PROPOSED RESIDENTIAL APARTMENT COMPLEX 3-STORY

FREEDOM SPRINGS
734 WESTERN DRIVE
COLORADO SPRINGS, EL PASO COUNTY,
COLORADO 80915

SITE DEVELOPMENT PLAN
SDP

ADA ROUTE DETAIL  
SCALE: 1" = 20"

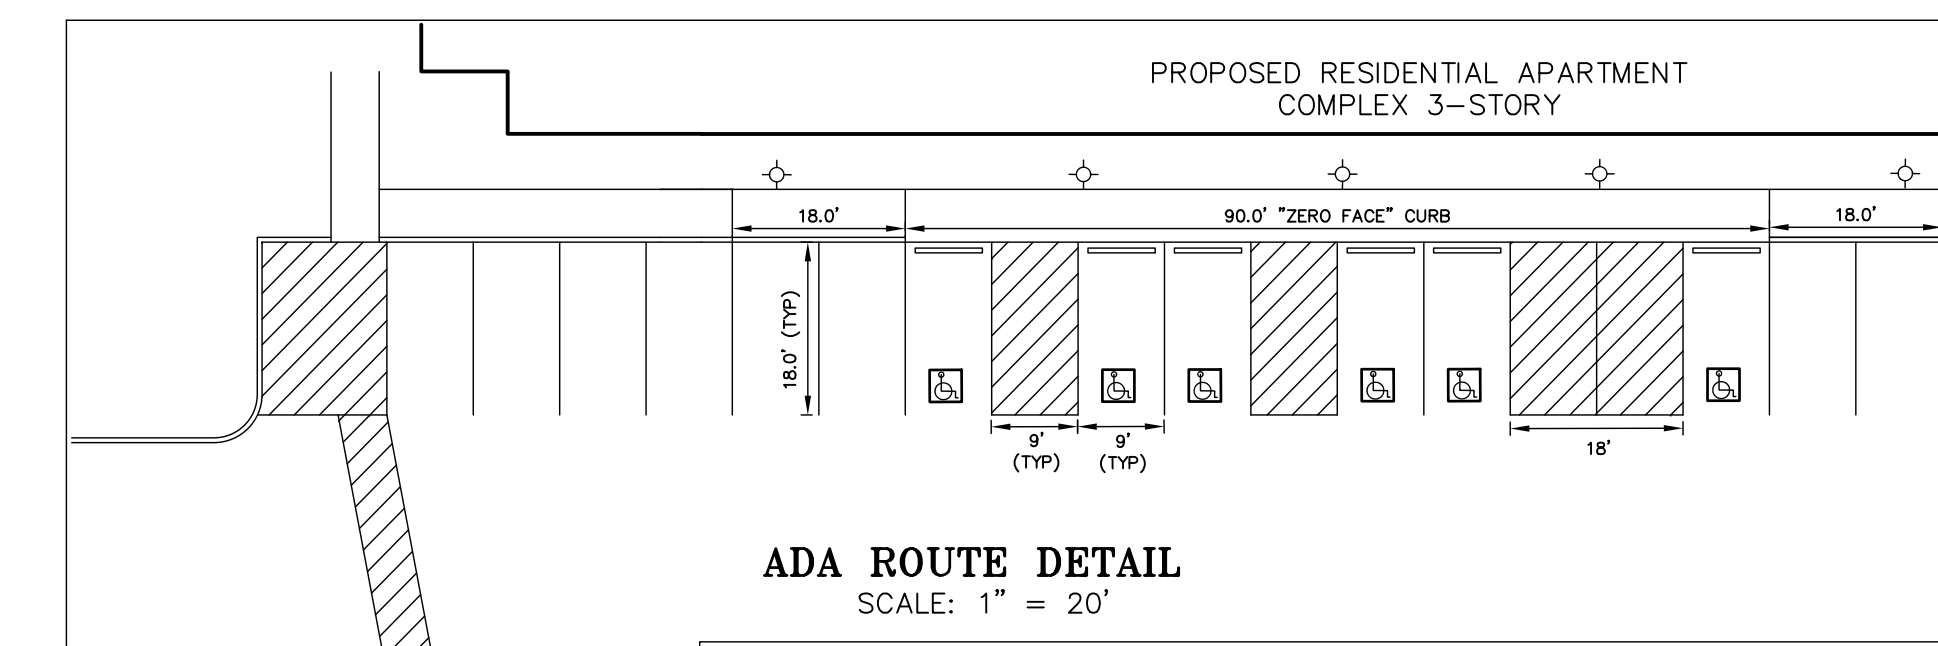
This is not an ADA route, this is showing the parking, per original comment, an separate sheet indicating the ADA route for the site is required.

1 SITE PLAN  
1" = 30'-0"

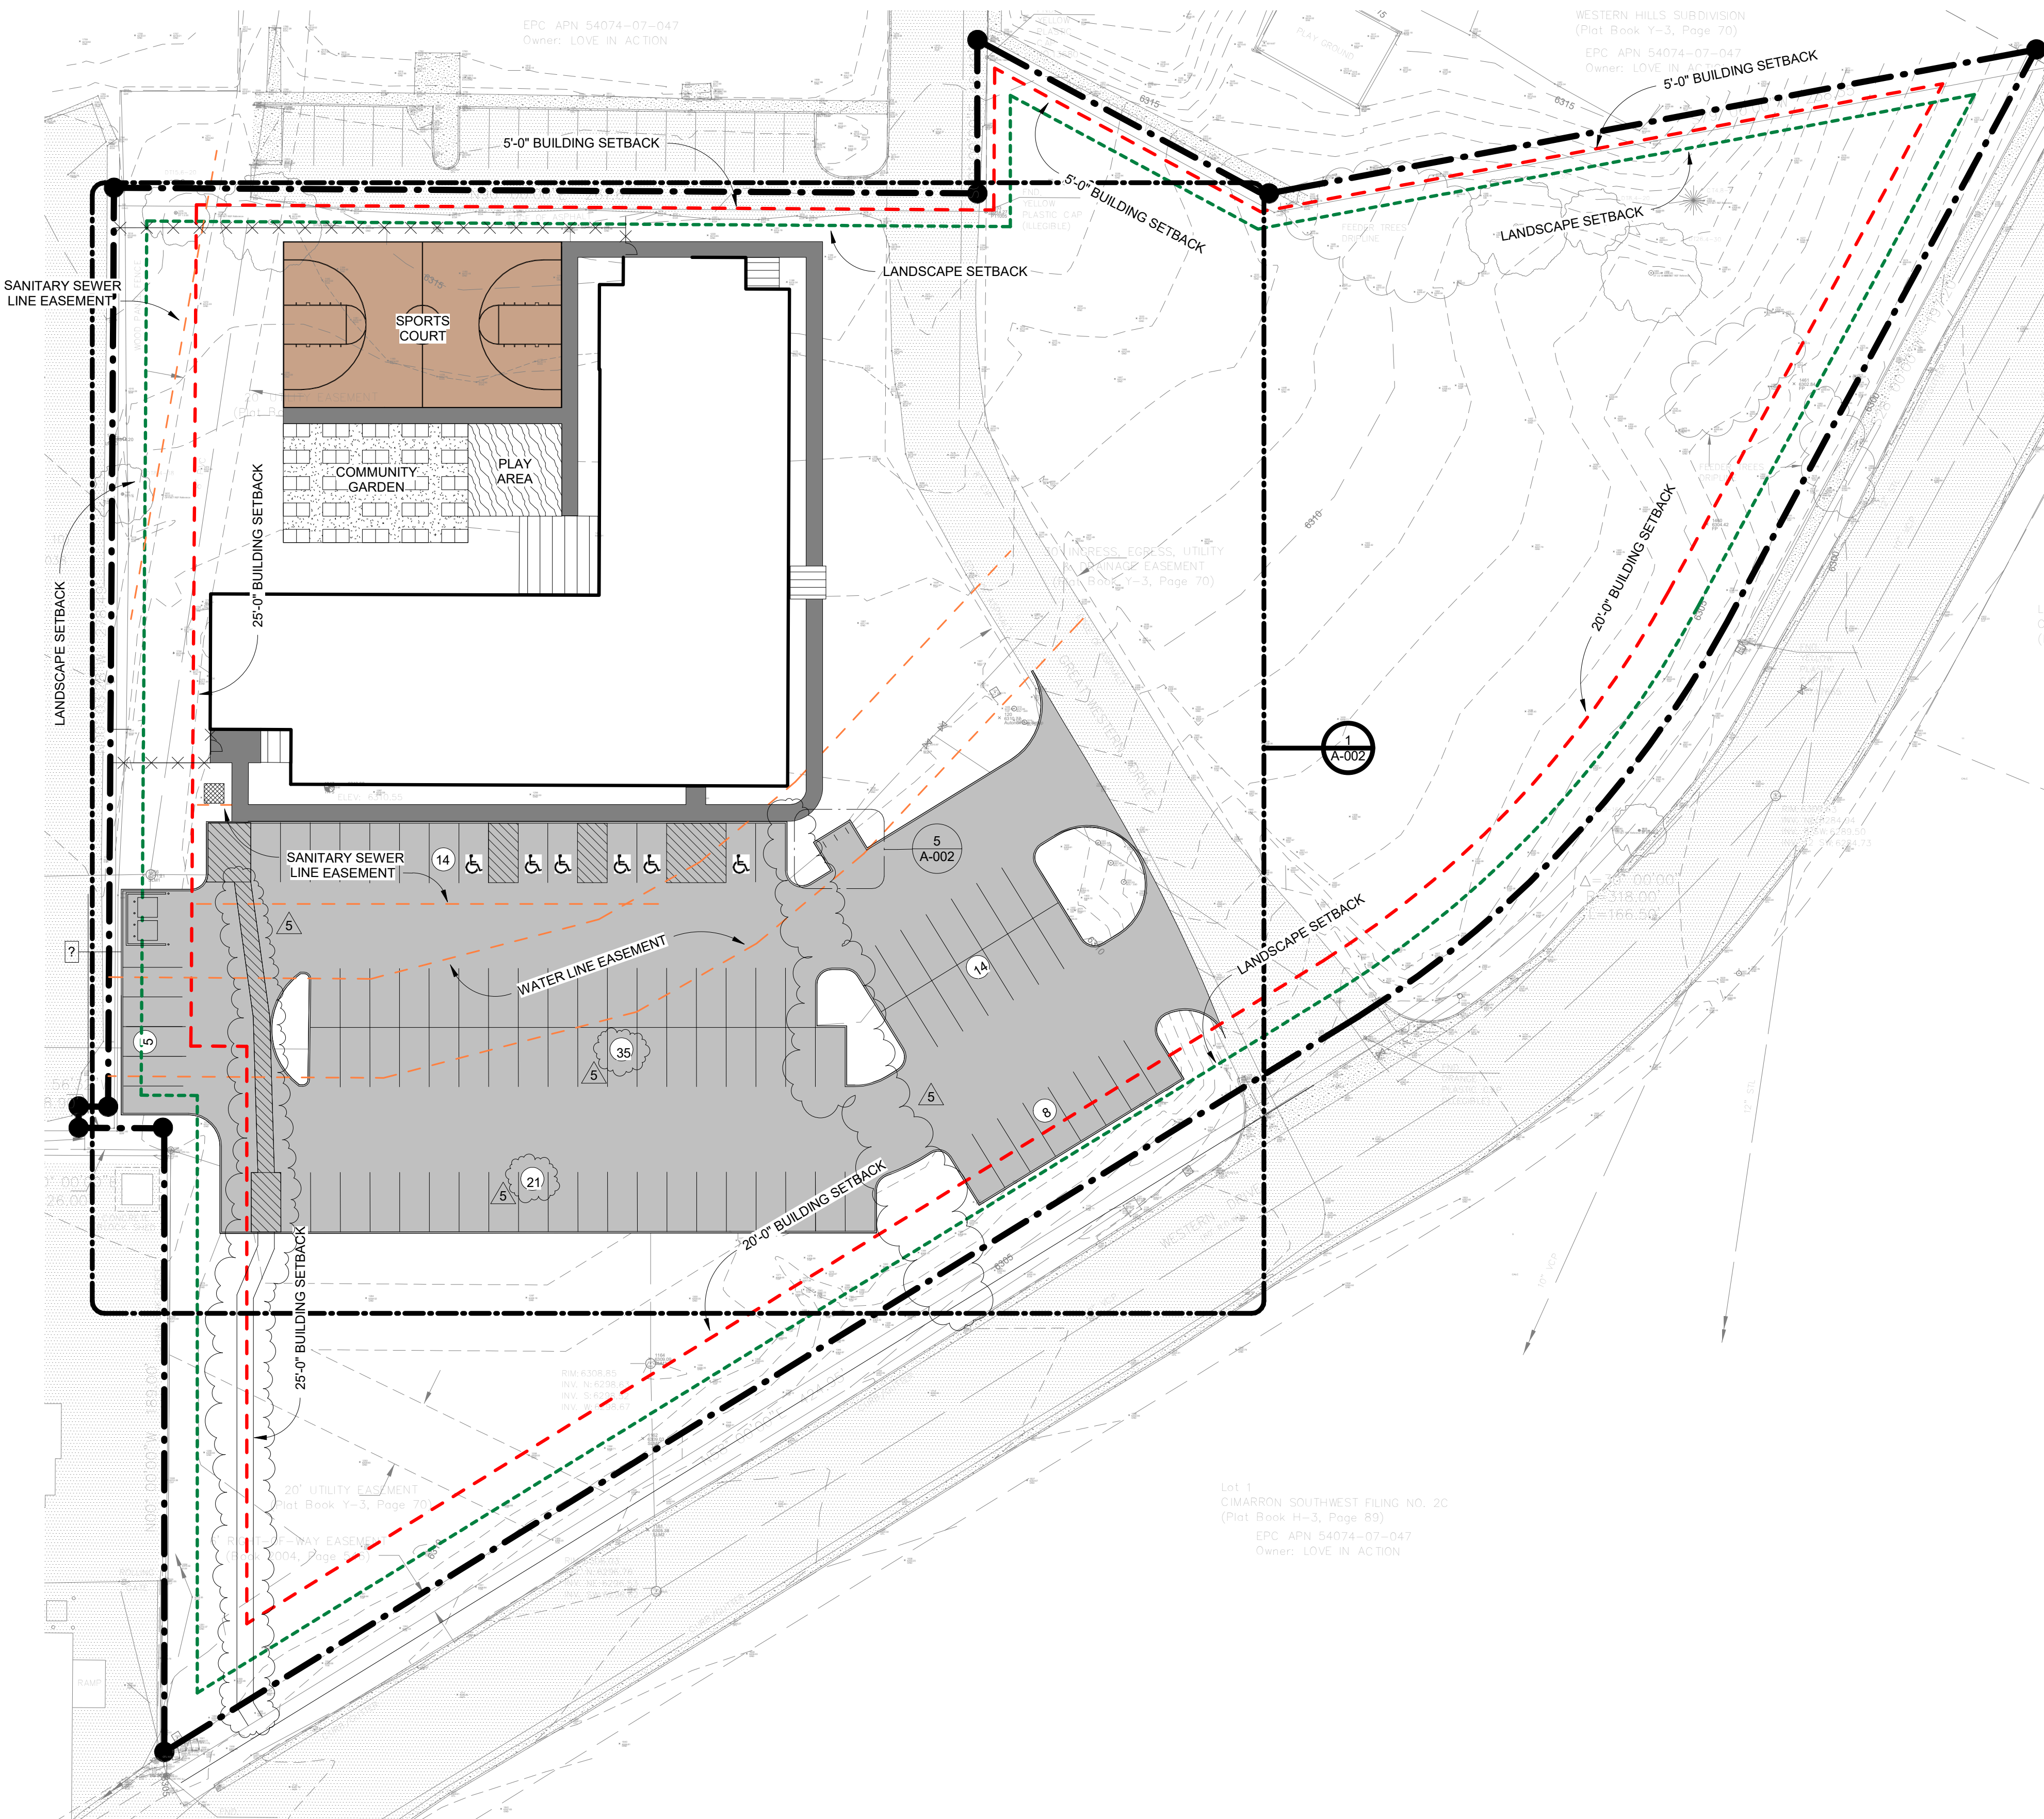
Review comment 1 stated "provide sidewalks connecting into the site and building" along the private street Great Western Drive. This revision shows a 4' sidewalk at a different location (above). However this new location is too steep; on a 4:1 slope and therefore will not accommodate ADA access. Please

Provide a condition on this site plan that areas shown as landscaping will need to remain as landscaped areas in perpetuity. These landscaped areas are part of the Stormwater Quality features associated with this development.

**1 ENLARGED SITE PLAN**  
1" = 20'-0"

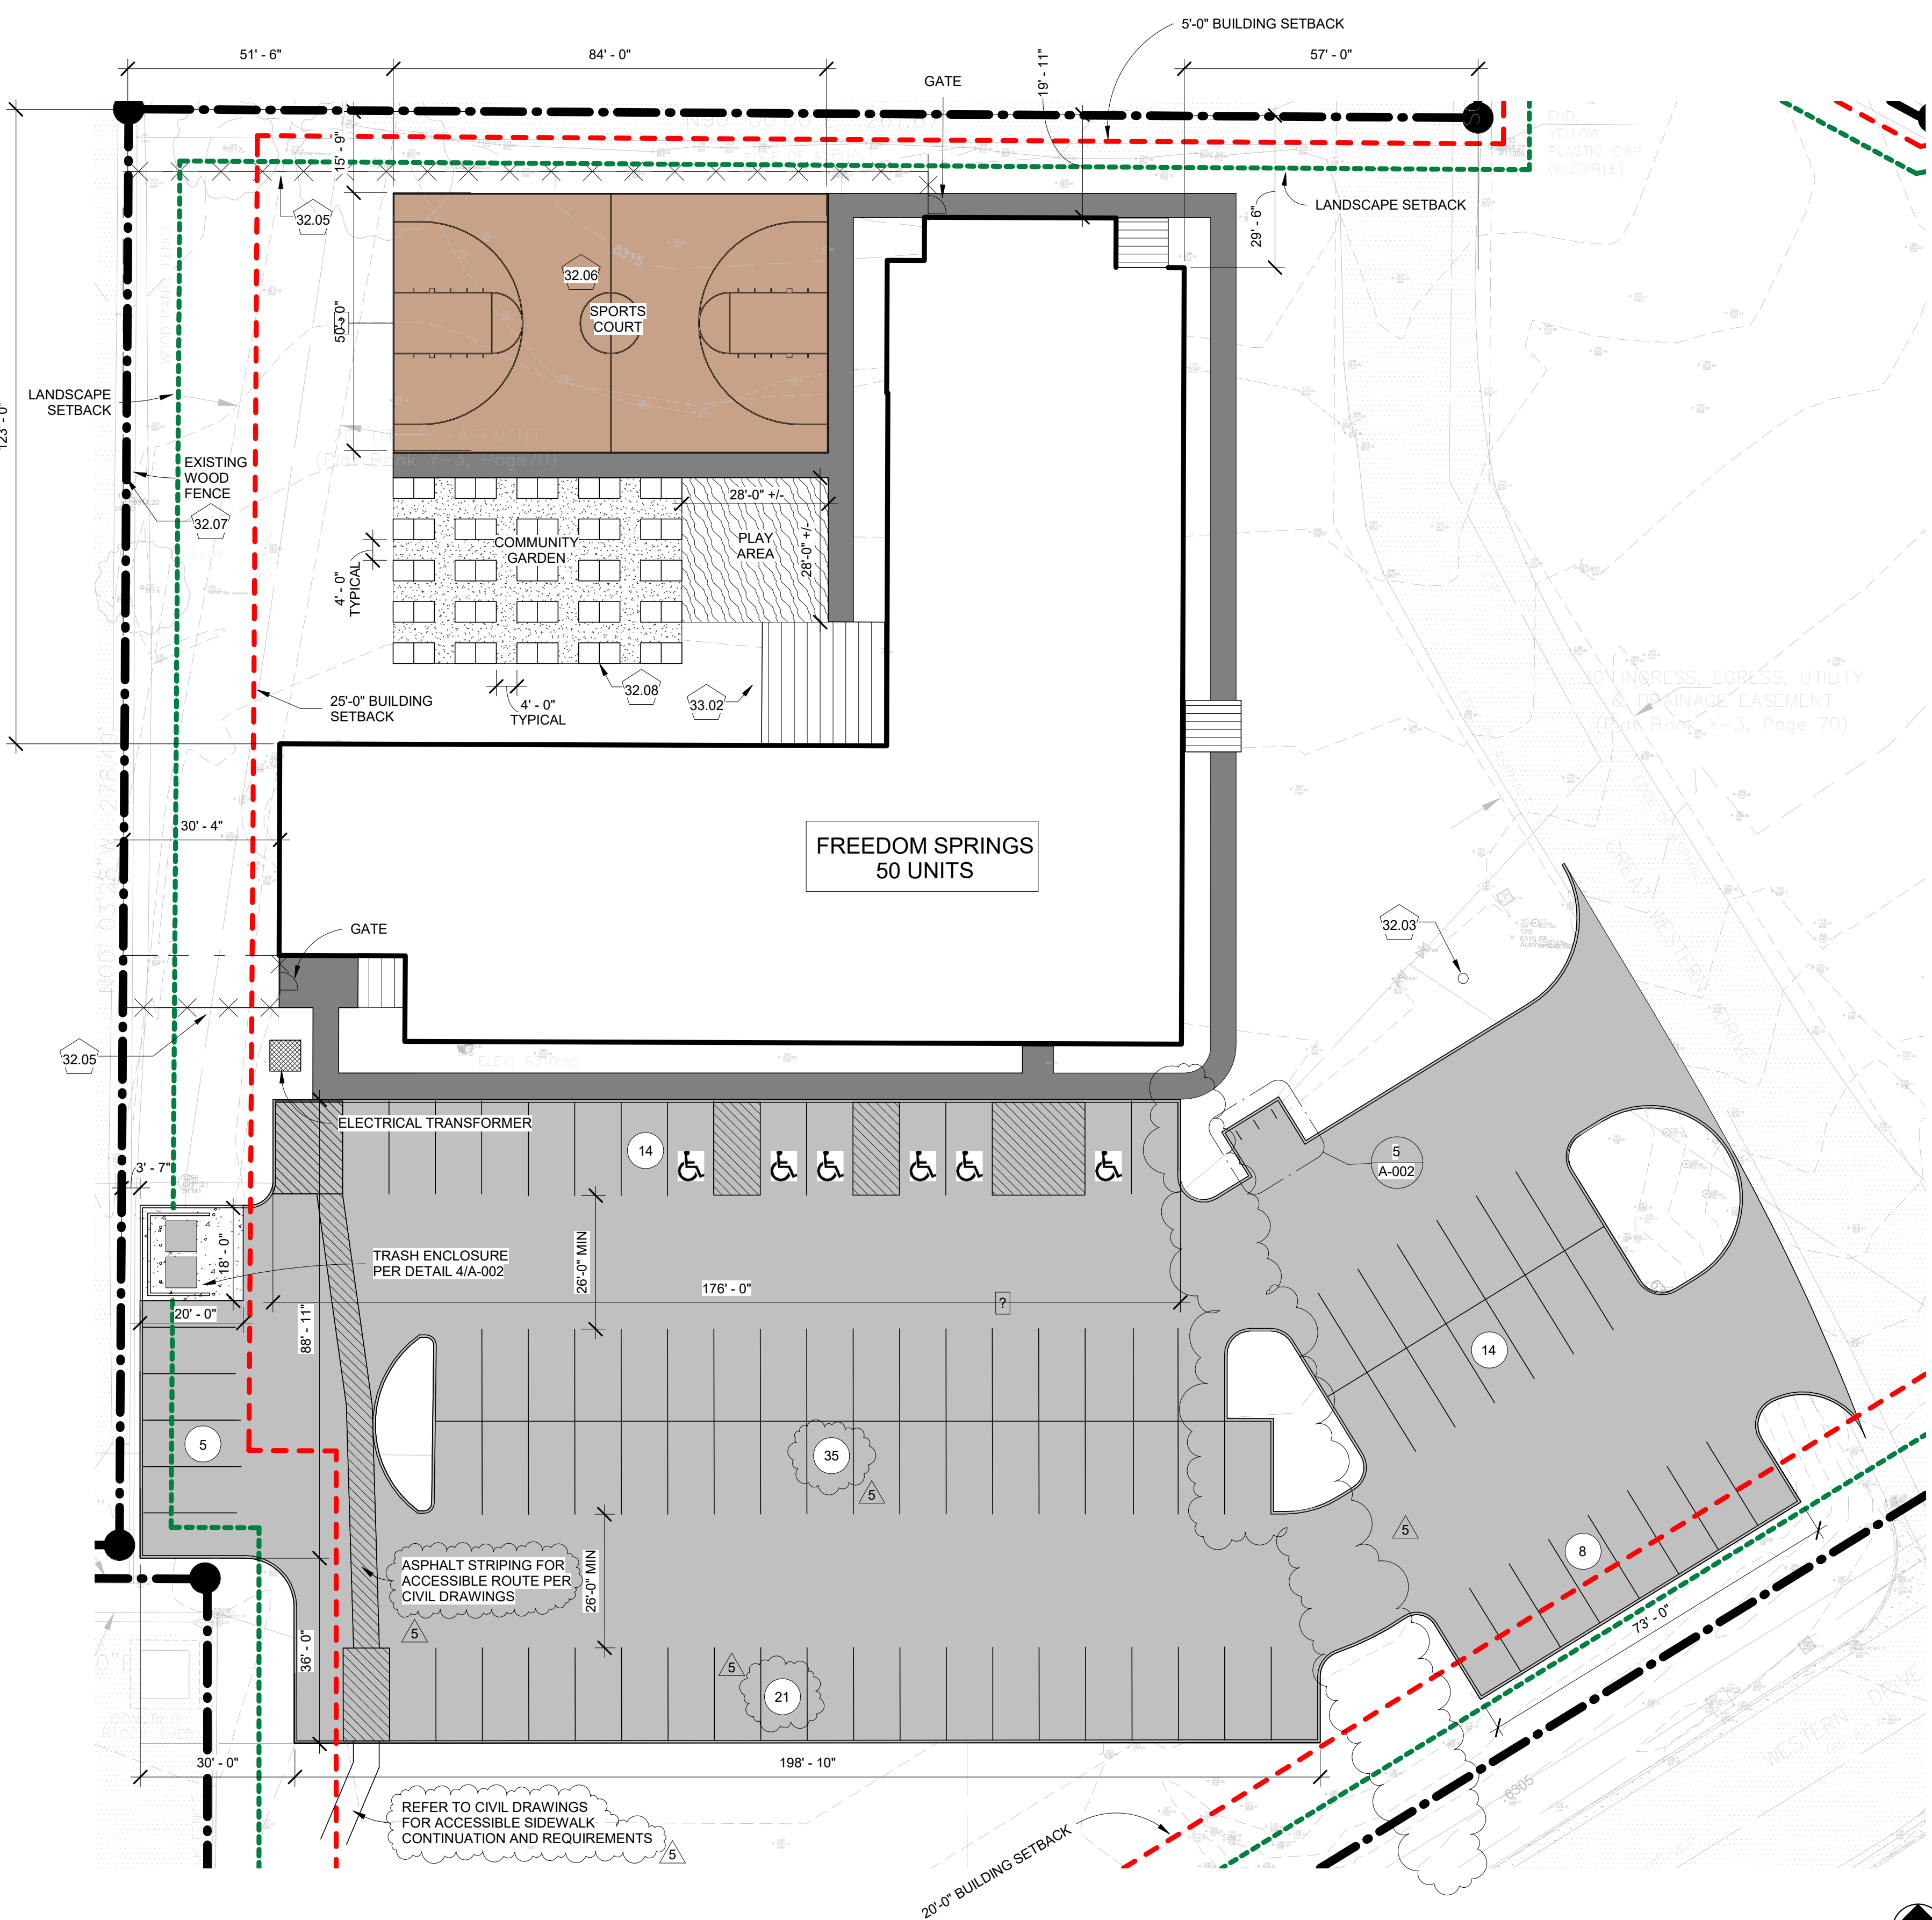
What is this page referring to? There is no legend, and at one point the red hatch line is shown to be a 20' building setback, in another a 5' building setback.
